**Tweed Valley Hospital Multi-Deck Carpark
SSD3 AMENDMENT REGISTER****DCR-SSD3**

We issue herewith the list of changes made on the drawings as sent in the nominate transmissions.

Transmittal Date 16.09.2022

1 ELEVATION NORTH
Scale: 1:200

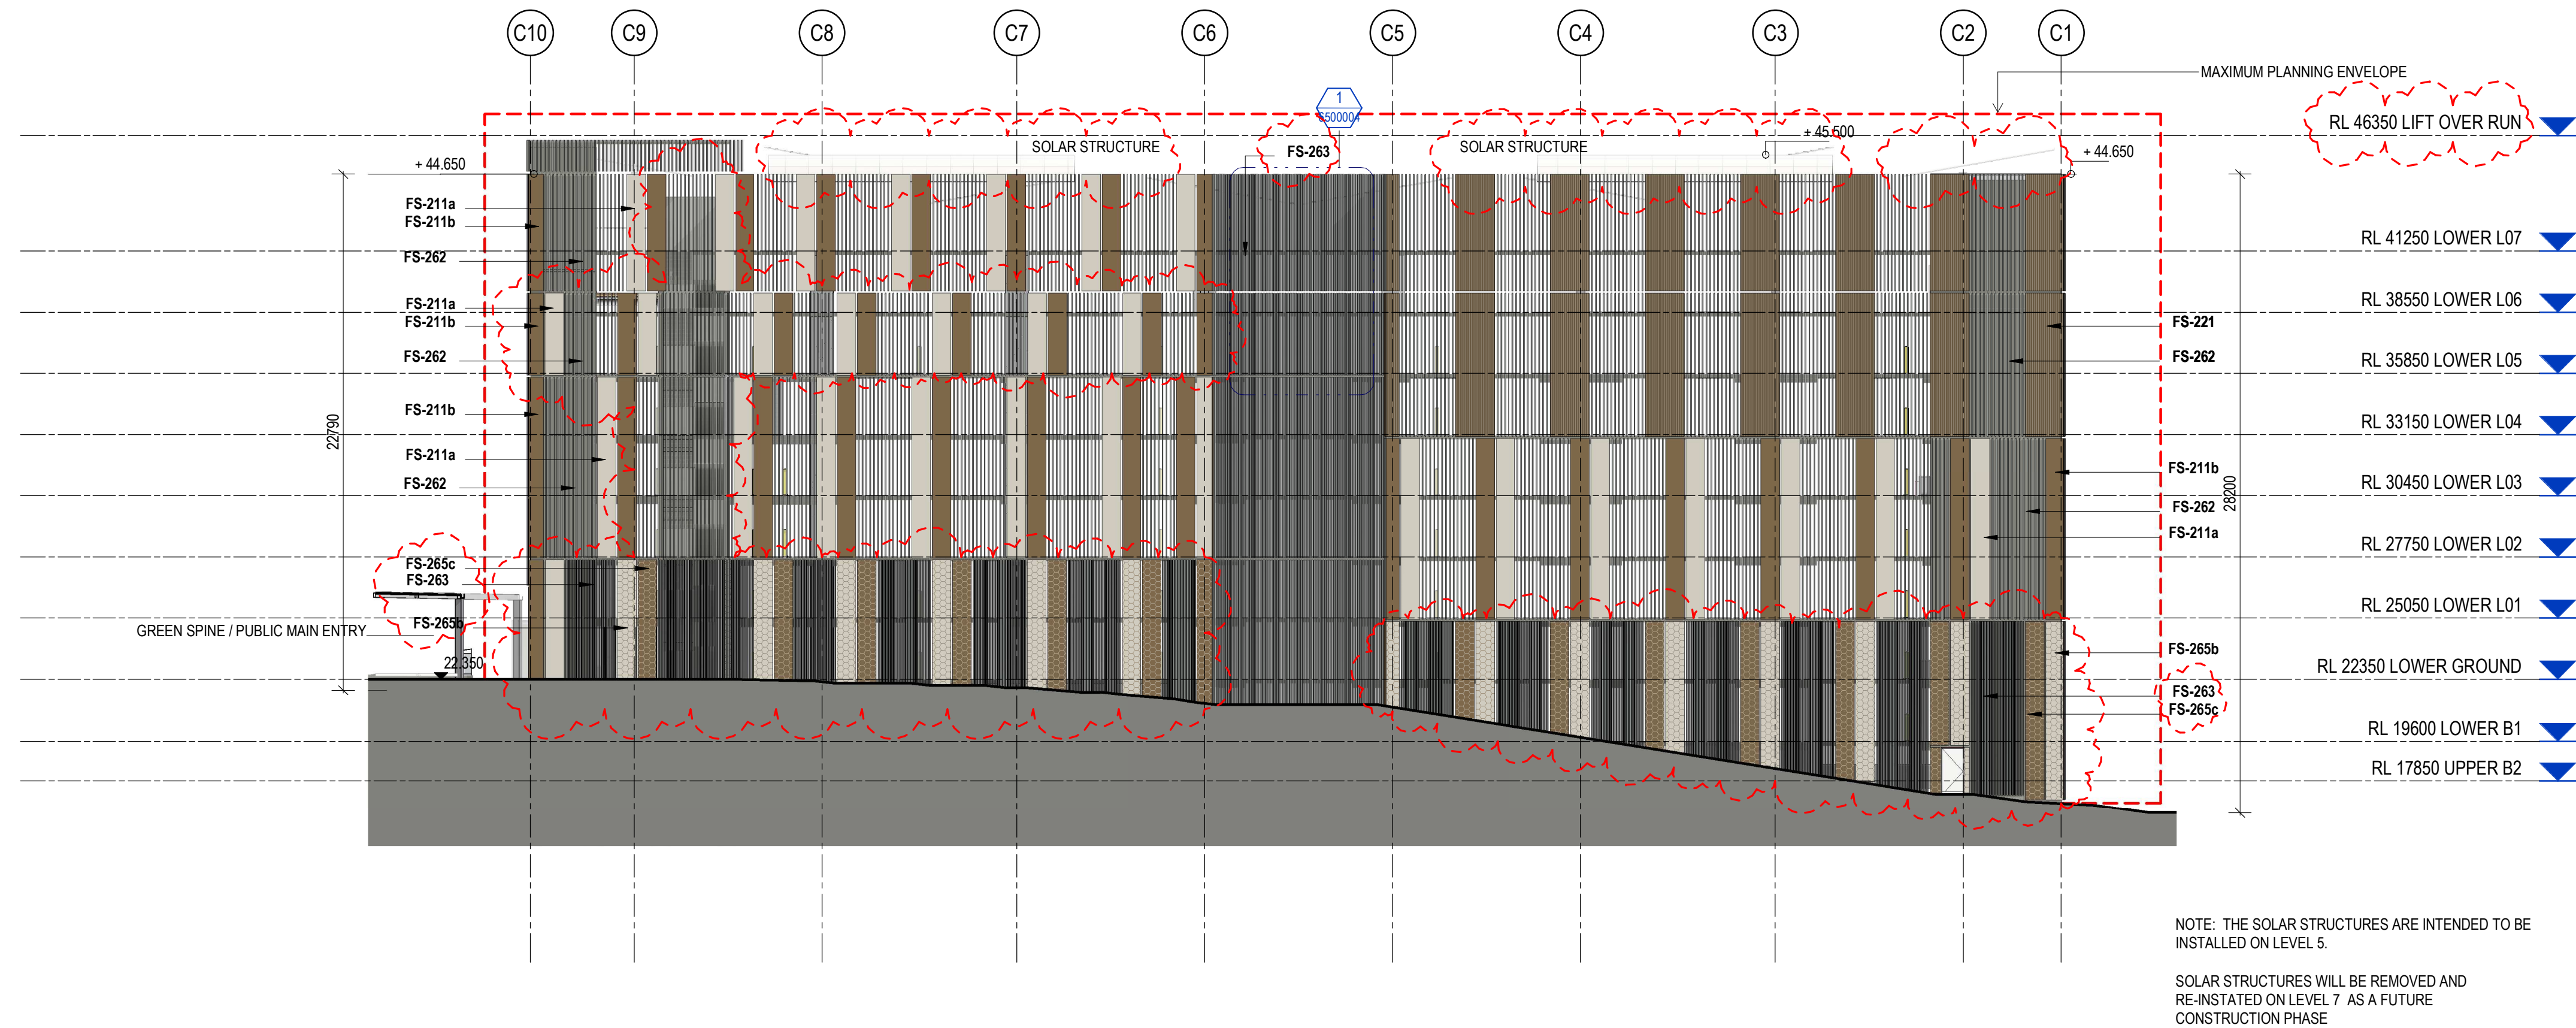
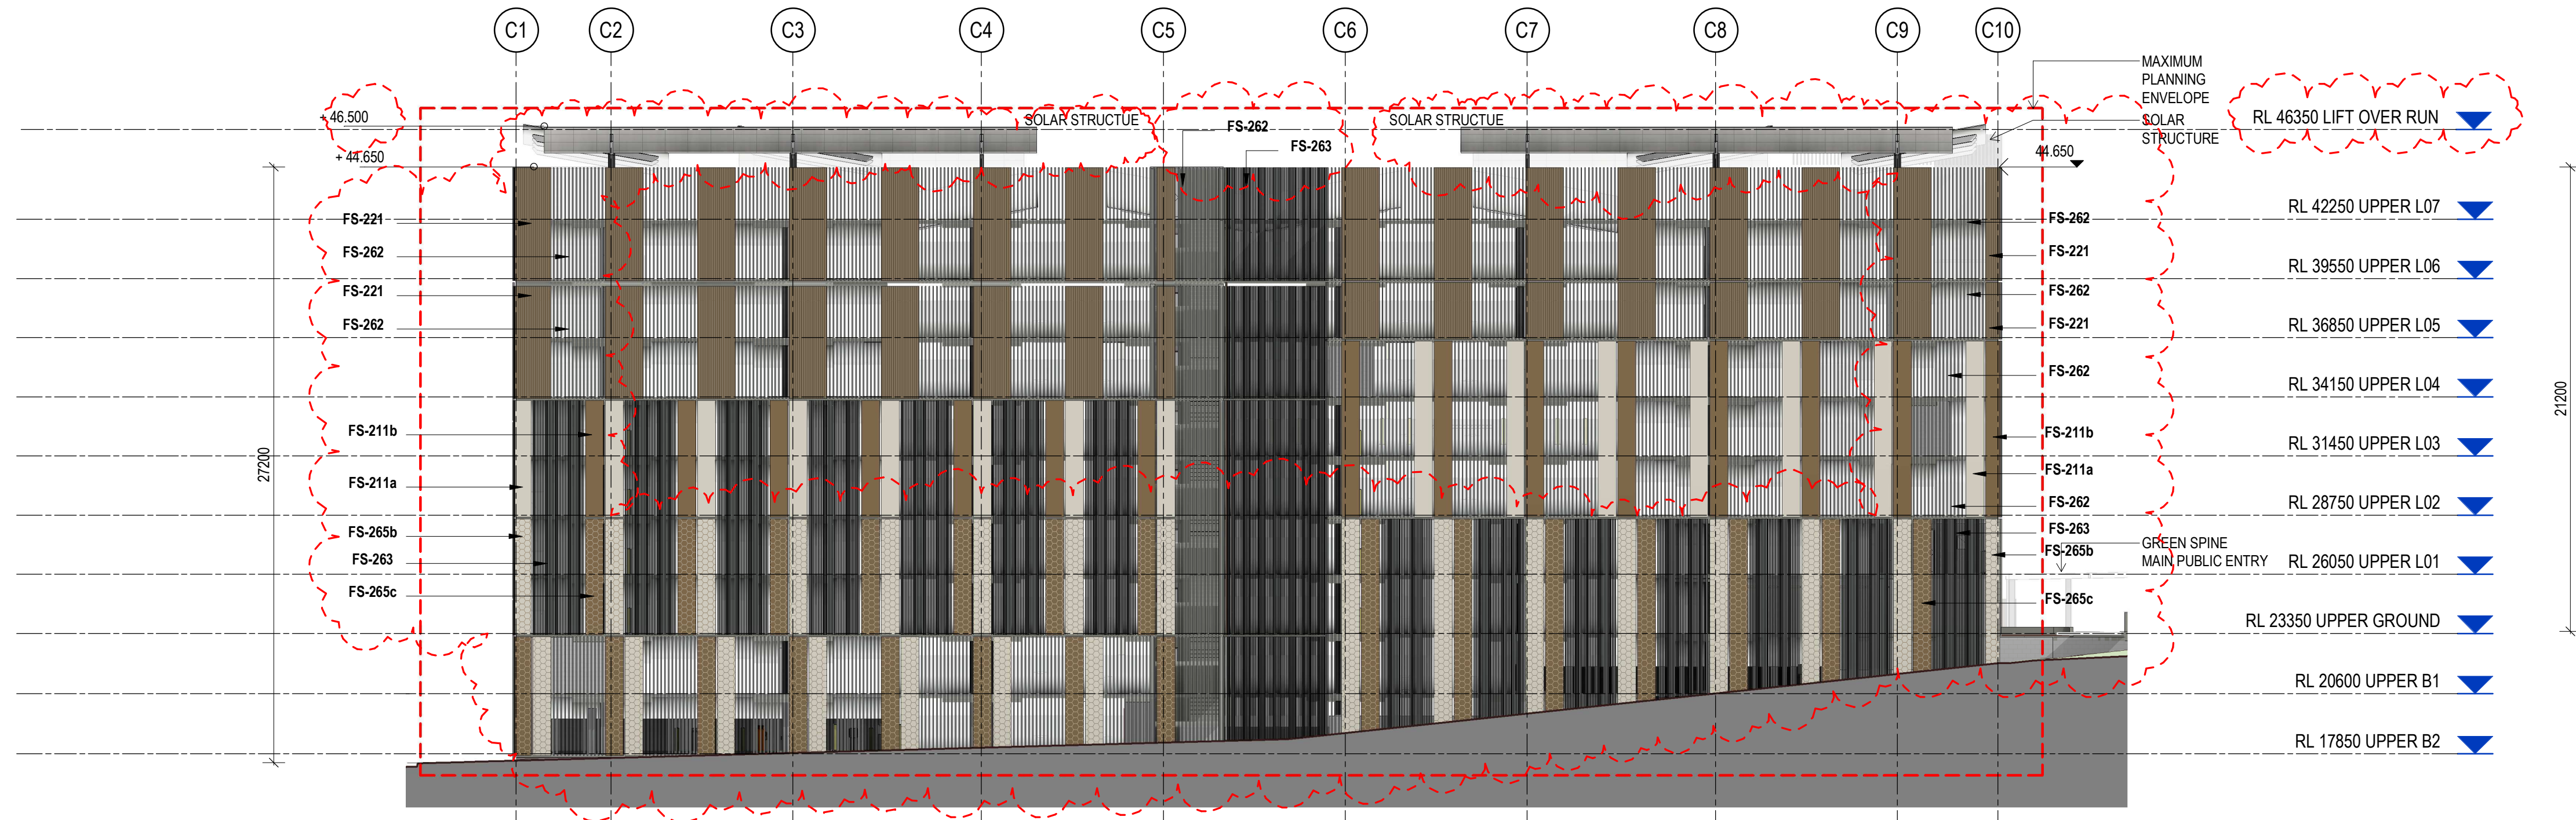
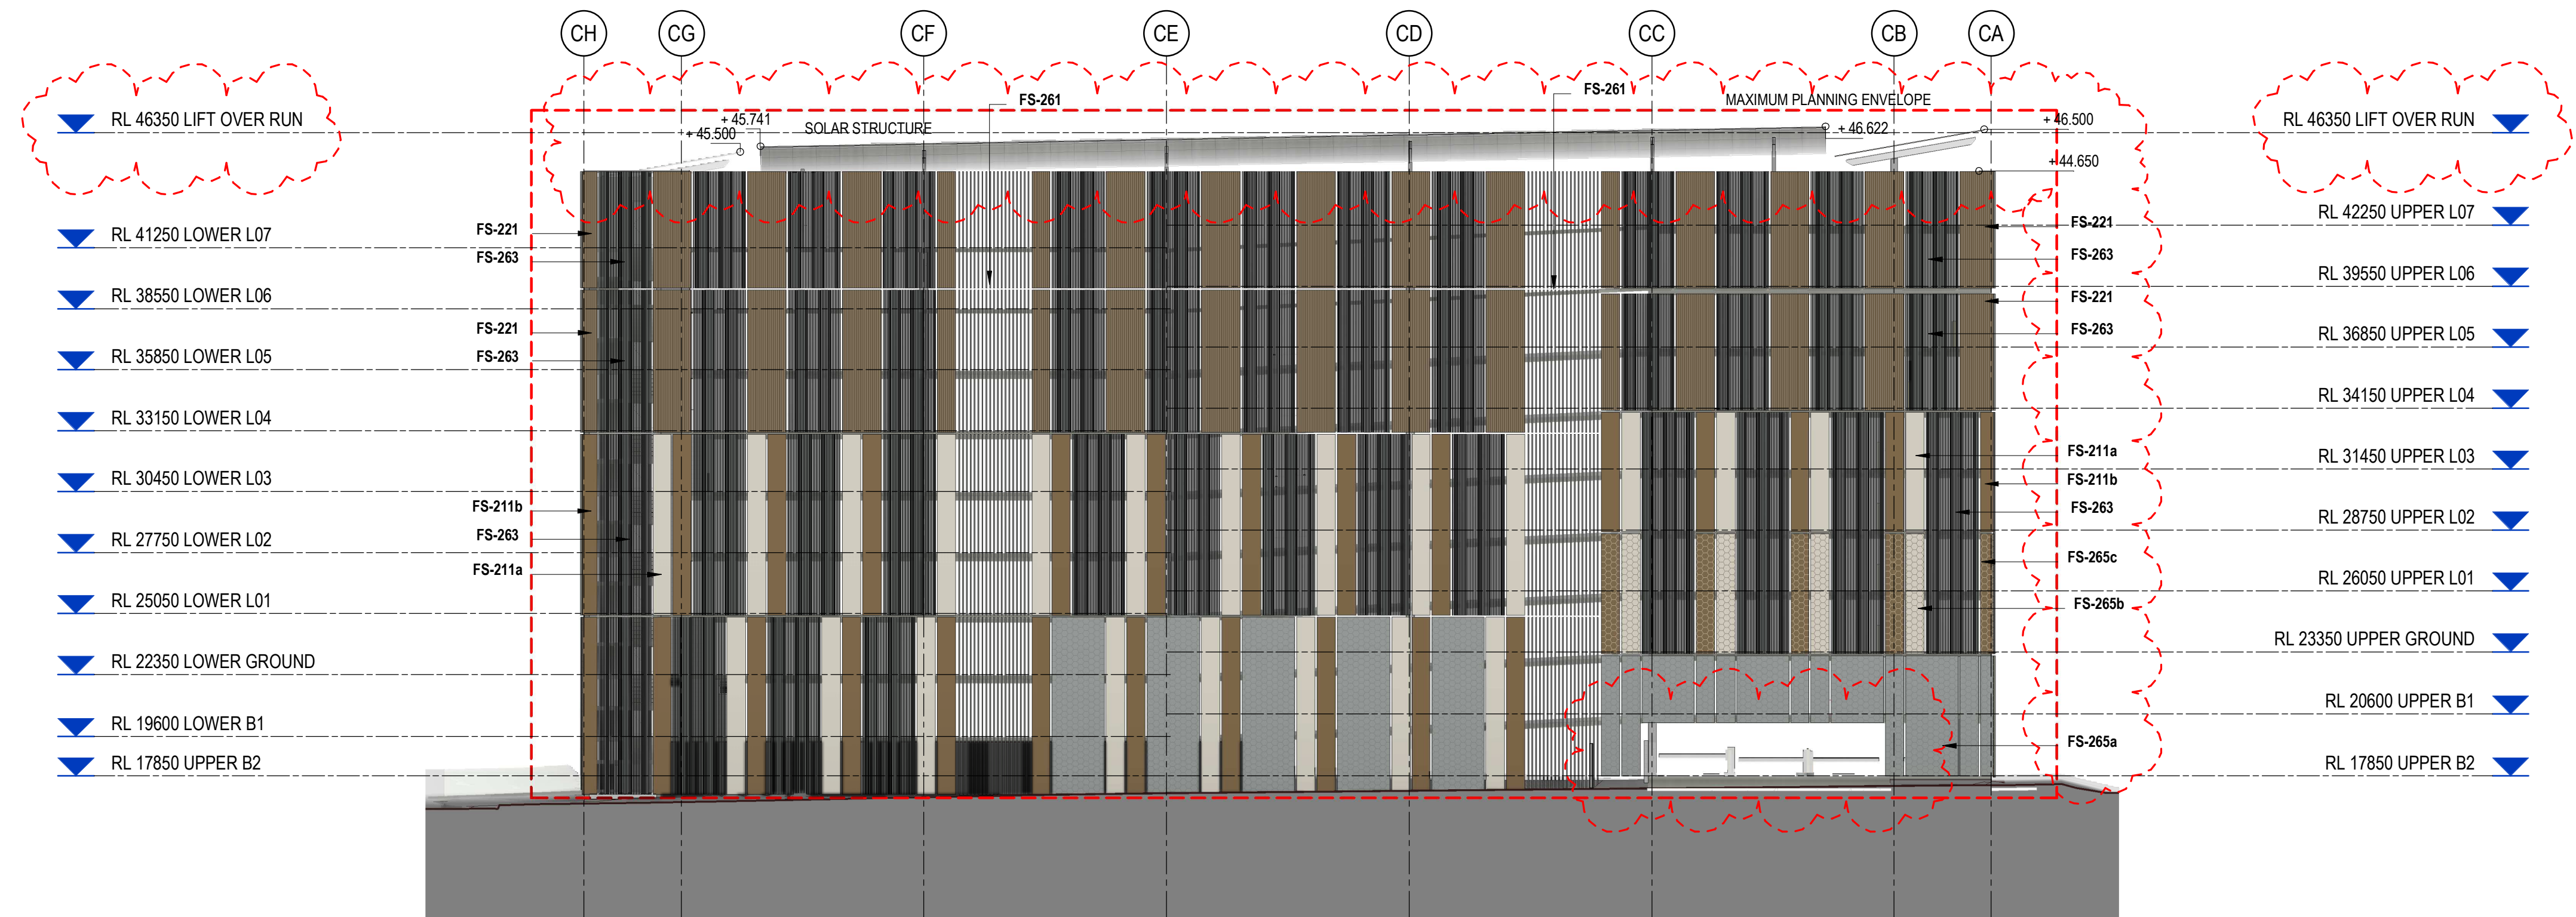
3	Roof Awning shown to lift lobby - part of design development	
			4	Turning bay shown along Grid CC / C4 and C7 as per Traffic Engineers advice, to become parking bays in future construction stage of Levels 6 and 7	
			5	Accessible parking bay clear zone defined	
			6	Drainage Wastes amended from Circular to square type as part of design development	
MDD-AR-SKE-MCP-2007001	FLOOR PLAN LEVEL 7	4	1	General Arrangement of Solar Structures developed as part of detailed design as per supplier advice, parking bays adjusted where required to maintain compliance	
MDD-AR-SKE-MCP-2500001	LIFT OVERUN - LVL7 / ROOF PLAN	8	1	General Arrangement and orientation of Solar Structures developed as part of detailed design as per supplier advice	
			2	Lift Over Run RL amended to suit Vertical Transport Manufacturer Requirements	
MDD-AR-SKE-MCP-4000001	ELEVATIONS	7	1	Façade Types amended to meet requirements of FEBQ and FRNSW

MDD-AR-SKE-MCP-4000002		7	2	Façade Types Legend Amended to reflect proposed materials. Finish Codes deleted, refer to finishes schedule for selections	
			3	East Elevation Covered Walkway Extended and Café Tenancy Entry Shown
